**City of Portland, Maine - Building or Use Permit Application**  
 389 Congress Street, 04101 Tel: (207) 874-8703, Fax: (207) 874-8716

<b>Permit No:</b> 06-0041	<b>Issue Date:</b>	<b>CBL:</b> 168 C004001
------------------------------	--------------------	----------------------------

<b>Location of Construction:</b> 704 WASHINGTON AVE	<b>Owner Name:</b> BELLUCCI ANTONIETTA G HRS	<b>Owner Address:</b> 704 WASHINGTON AVE	<b>Phone:</b>
<b>Business Name:</b>	<b>Contractor Name:</b>	<b>Contractor Address:</b>	<b>Phone:</b>
<b>Lessee/Buyer's Name</b>	<b>Phone:</b>	<b>Permit Type:</b> Change of Use - Dwellings	<b>Zone:</b>

<b>Past Use:</b> single family	<b>Proposed Use:</b> 2 unit residential/ Change of use from single family to two family/ add Kitchen, partitions & upgrade bathroom	<b>Permit Fee:</b> \$150.00	<b>Cost of Work:</b> \$6,000.00	<b>CEO District:</b> 4
		<b>FIRE DEPT:</b> <input type="checkbox"/> Approved <input type="checkbox"/> Denied	<b>INSPECTION:</b> Use Group: Type

704 WASHINGTON AVE
PURPOSED PROJECT

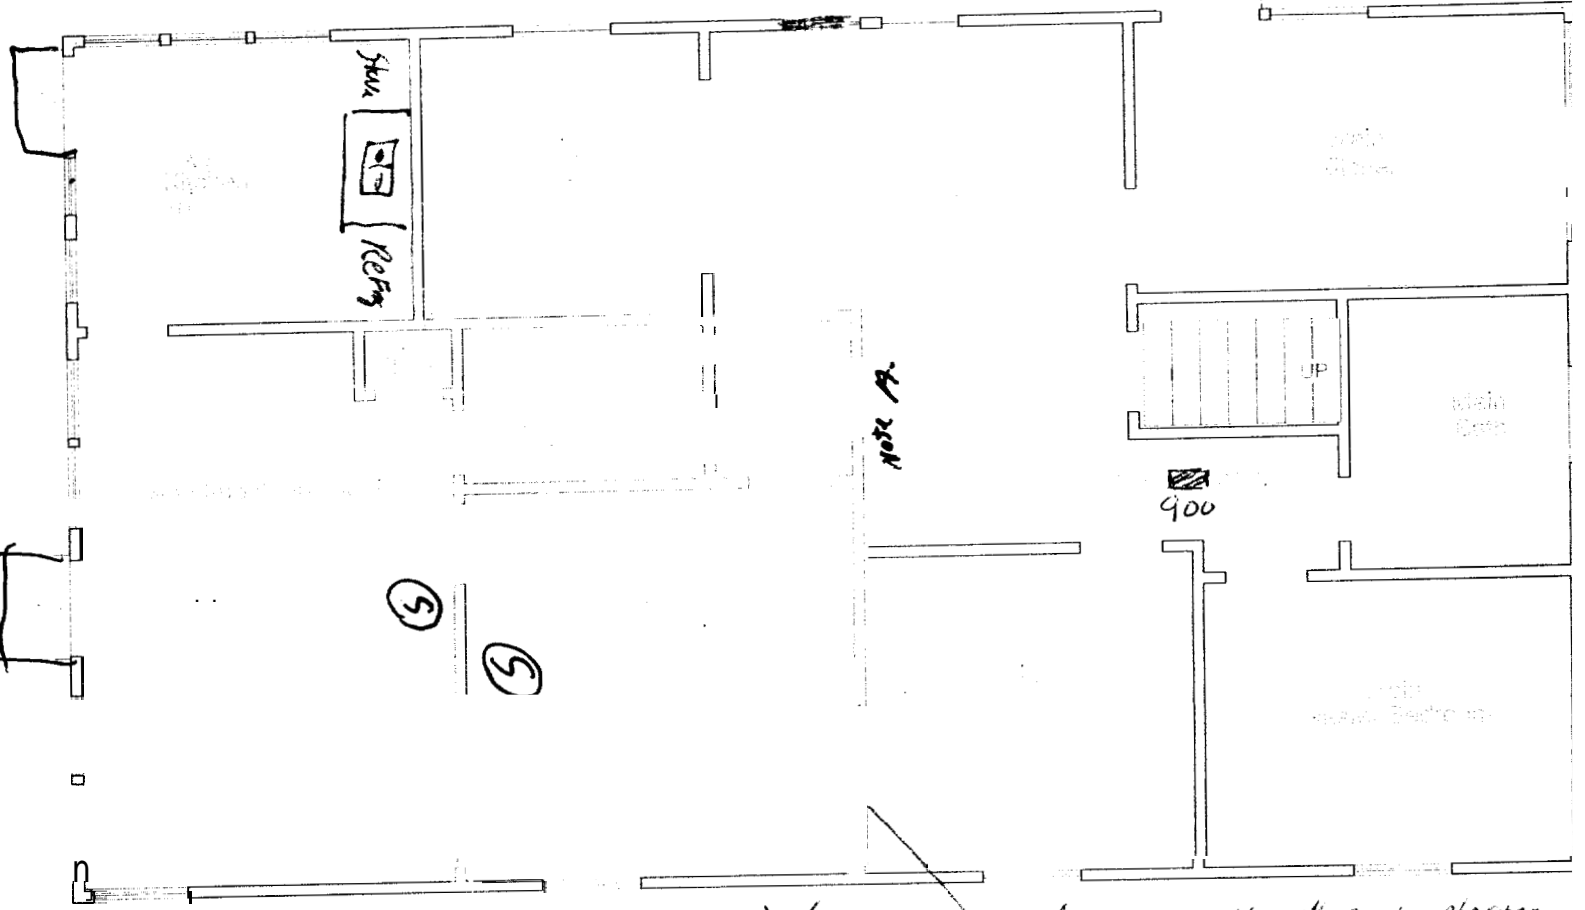
- 1) Permit approved based on the plans submitted and reviewed w/owner/contractor, with additional information as agreed on and as noted on plans.
- 2) All penetrations between dwelling units and dwelling units and common areas shall be protected with approved firestop materials, and recessed lighting/vent fixtures shall not reduce the (1 hour) required rating.
- 3) Separate permits are required for any electrical, plumbing, or heating.

1/10/06-ldobson: filed site plan exemption 01092006  
2/2/06-tmm: left message w/owner - need to discuss firewall and any penetrations
